Re: 230169DS1

Project Customer:	-	Project Name:	230169DS1
Lot/Block:	81	Subdivision:	Serenity
Address:	141 Serenity	Model:	Forget Me Not
City:	Fuquay Varina, NC	State:	North Carolina

The Truss Manufacturer (TM) is Carolina Structural Systems

Job 230169DS1	Truss F206	Truss Type Floor	Qty 1	Ply 1	Garman Homes - Forget Me Not A & B Paragon ID: 43151 P4602422 Job Reference (optional)
------------------	---------------	---------------------	----------	----------	---

Job Q2200850	Truss F206	Truss Type Floor	Qty 1	Ply 1	Garman Homes - Forget Me Not B Floor Job Reference (optional)	I56500232
-----------------	---------------	---------------------	----------	----------	--	-----------

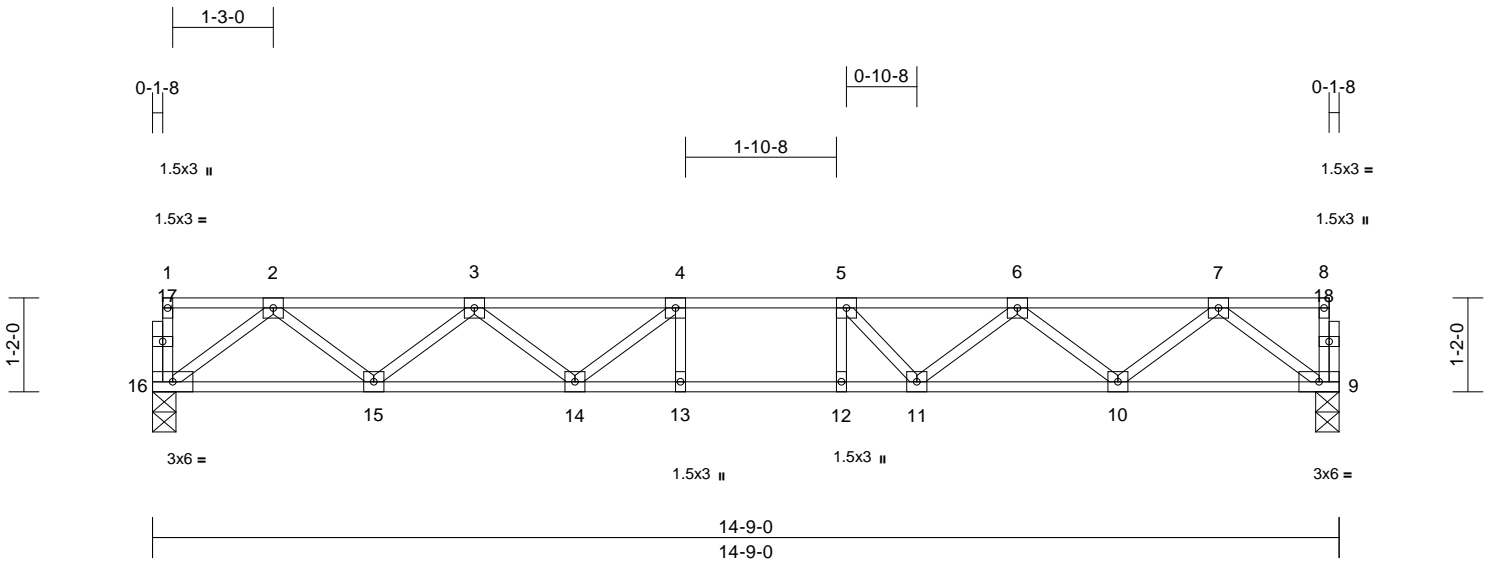
REPAIR:

1) STUB RIGHT END OF TRUSS 3' 6-1/2" AS SHOWN.

(A) LUMBER AND CONNECTOR PLATES TO BE CUT CLEANLY AND ACCURATELY AND THE REMAINING PLATE(S) MUST BE FULLY EMBEDDED AND UNDISTURBED. DO NOT OVERCUT.

***** NO FURTHER REPAIR(S) REQUIRED *****
